# HIGH MESA Consulting Group

2017.014.2  
September 26, 2017

RE: Letter Explaining How EPC Conditions Have Been Addressed – Project # 1005237  
Request for Final Sign-Off for EPC Approved SDP for Building Permit and SDP for  
Subdivision.  
Tracts A-1, Mark 3S Holly Development

1 West Elevation BLDG C

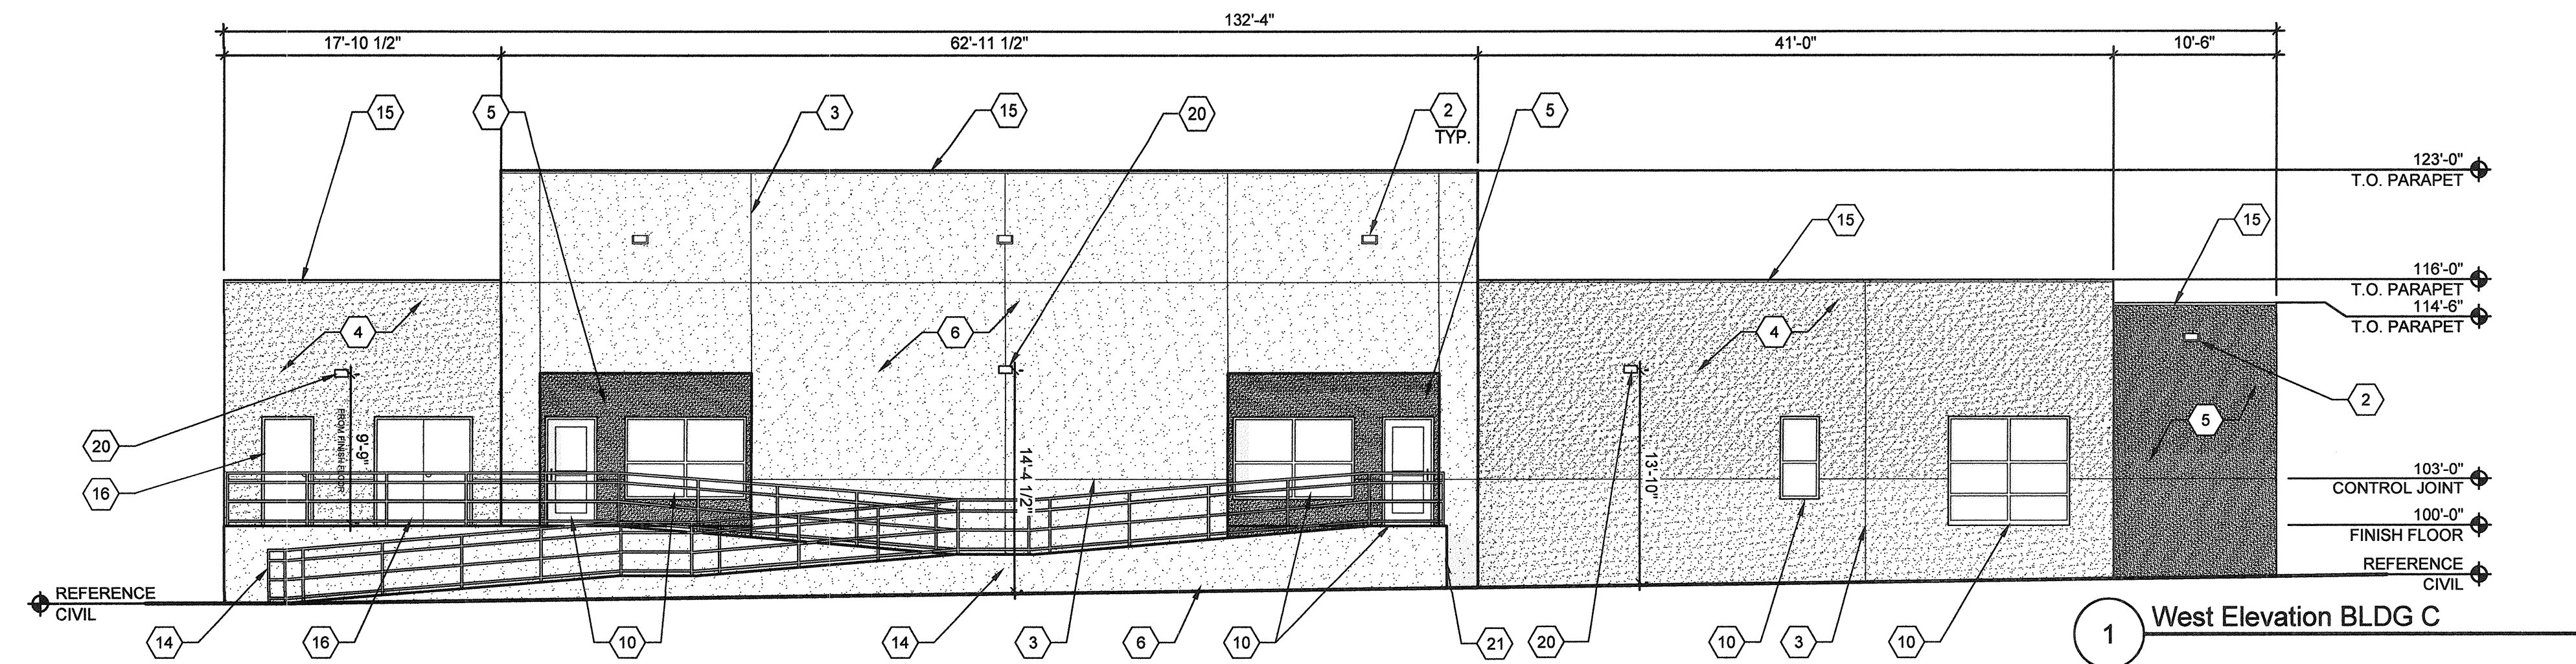
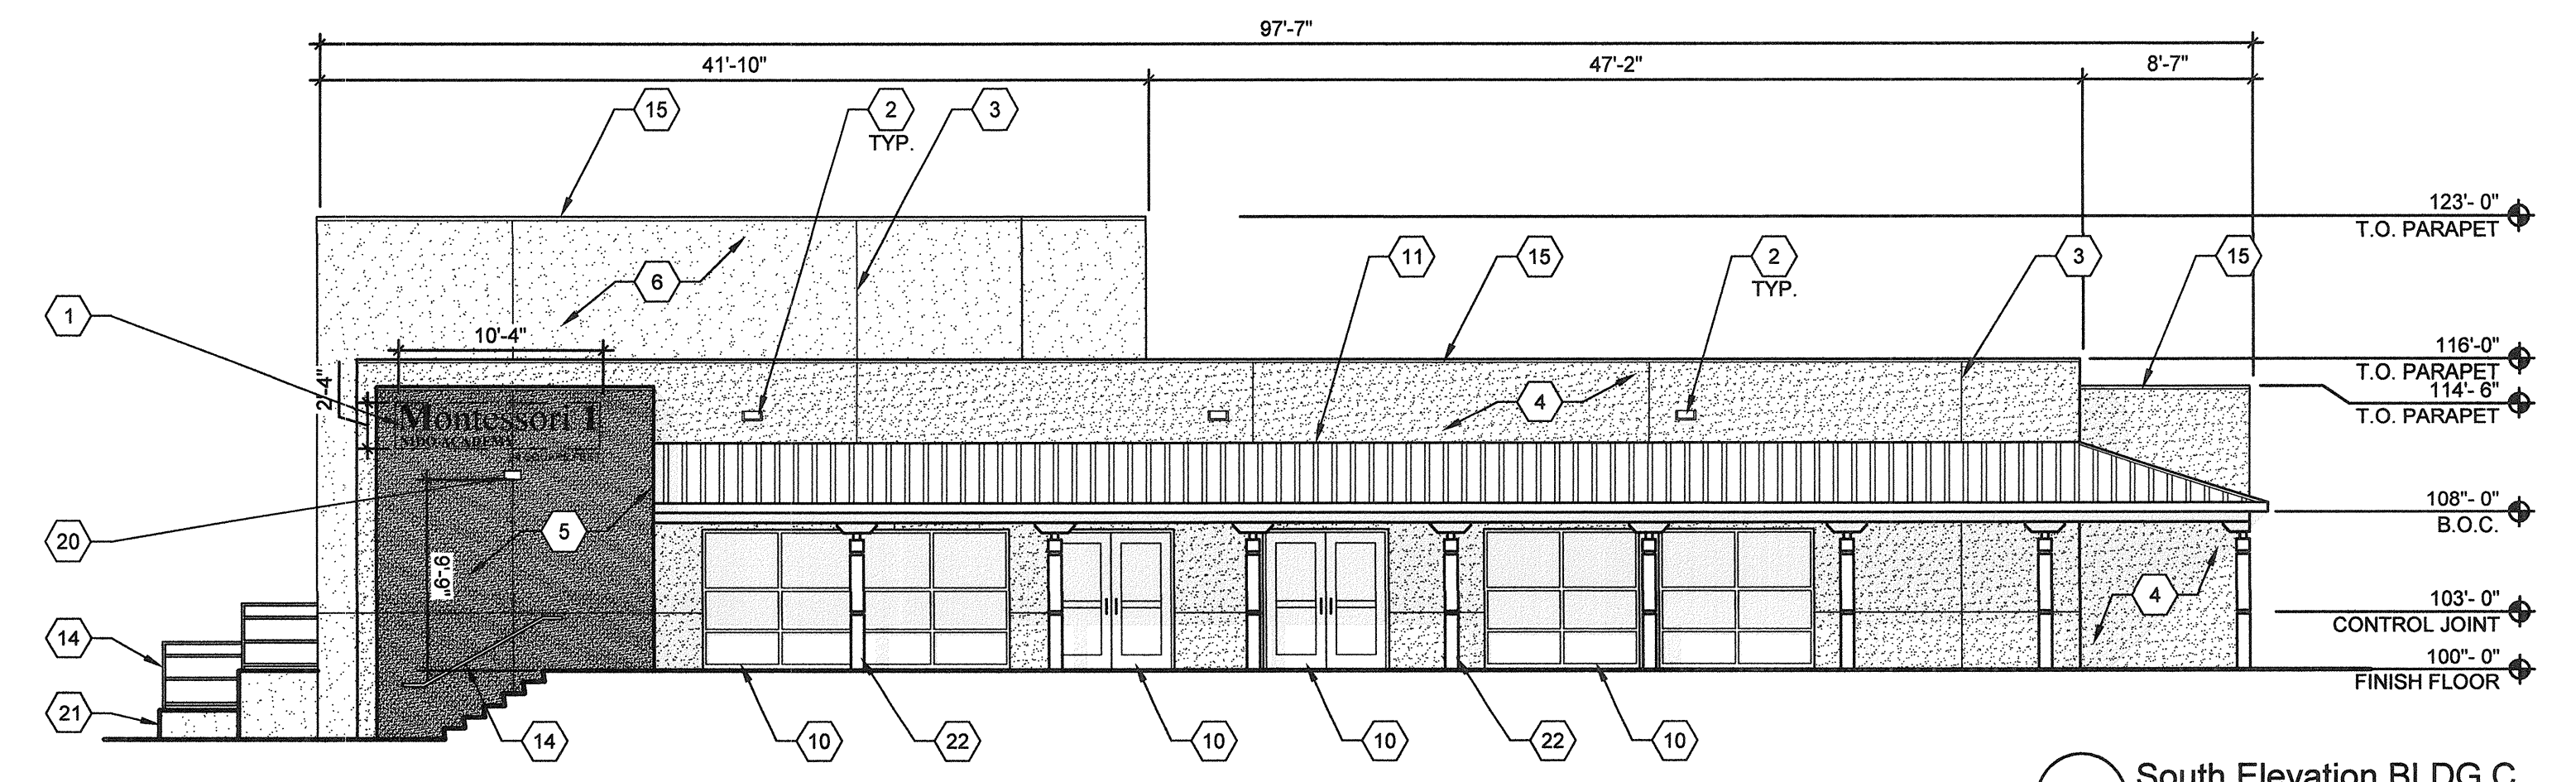
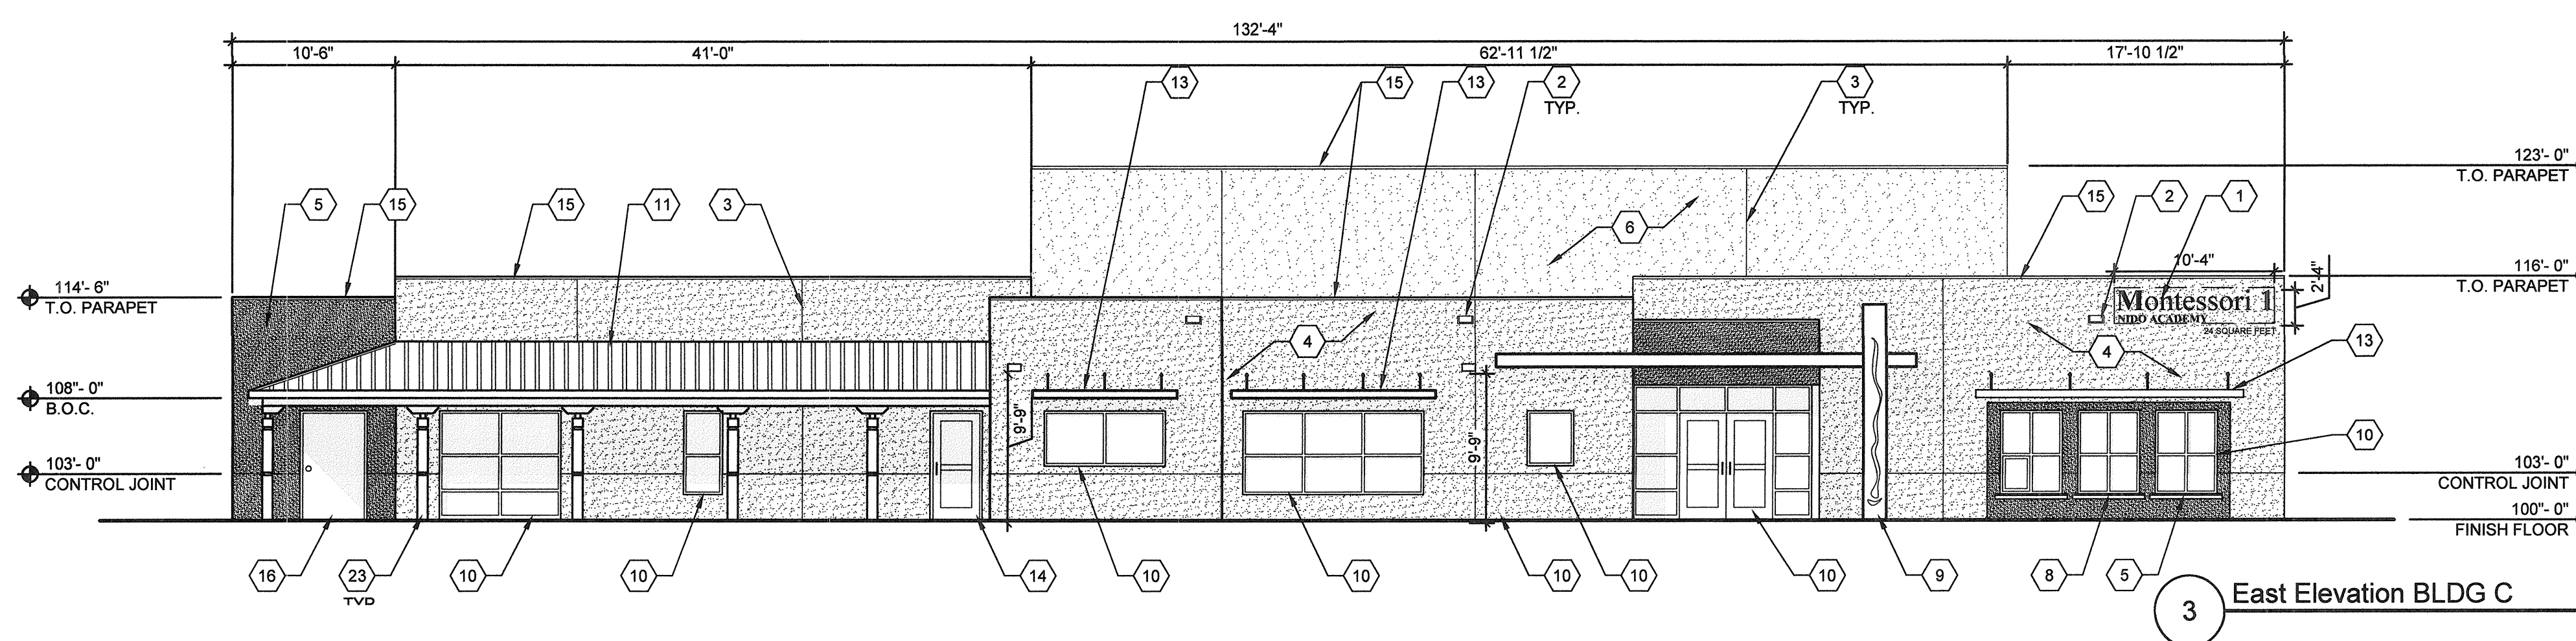
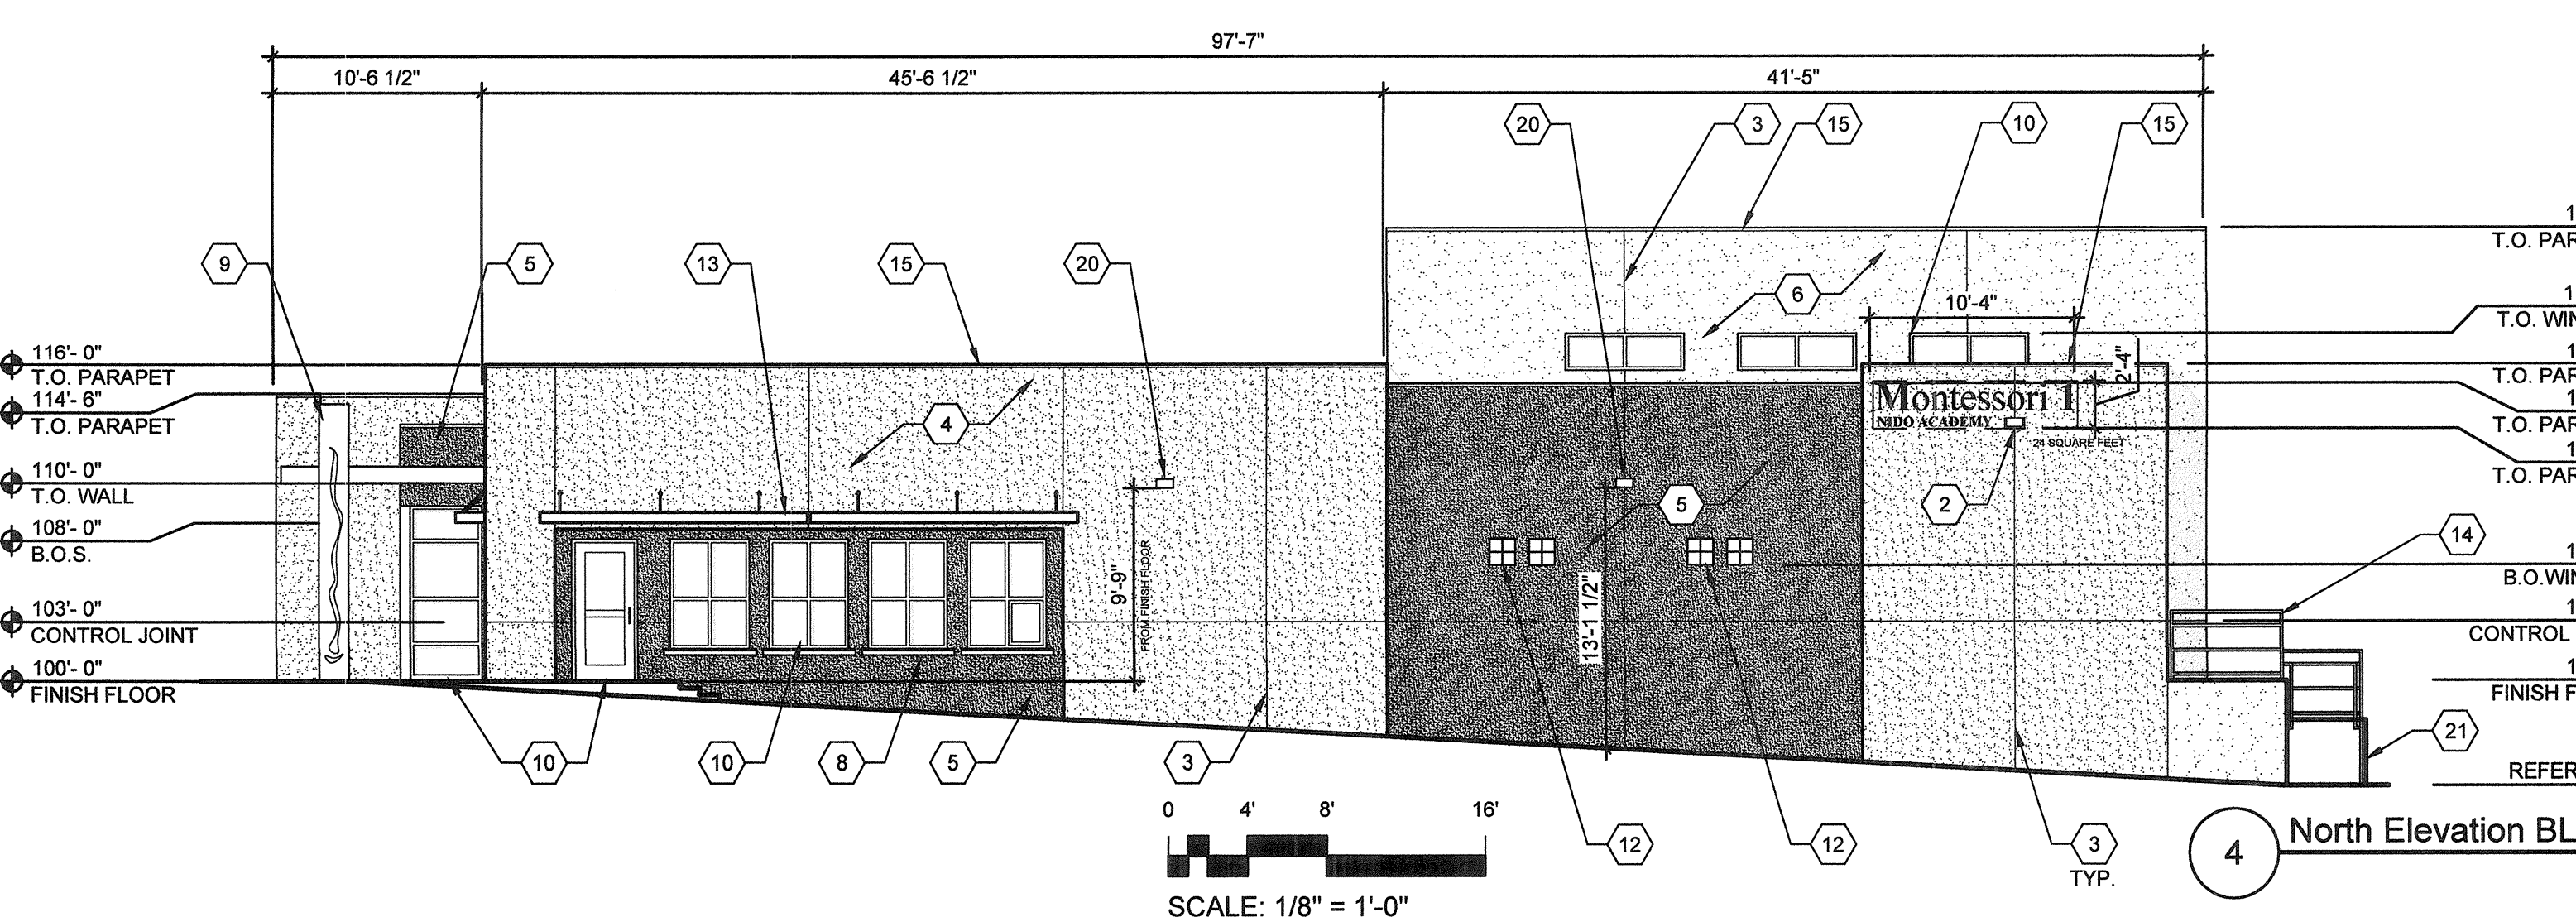
- A. The building mounted signage shall be dimensioned, with square footage totaled (LCSDP 13R-8). -*This has been dimensioned, with square footage totaled on Sheet 5.*
- B. The height to the building-mounted light fixtures shall be dimensioned (LCSDP 14R-6). -*This has been dimensioned on Sheet 5.*
- C. Colors and materials of the building-mounted signage shall be specified in a sign detail (LCSDP 13R-8). -*A sign detail was added to Sheet 5.*

- A. The building footprints shall be dimensioned and match the dimensions on the elevations. -*The building footprints is now dimensioned and matches the dimensions on the elevations sheet.*
- B. A note shall be added regarding roof color (LCSDP 9R-3). -*A note was added to Sheet 5.*
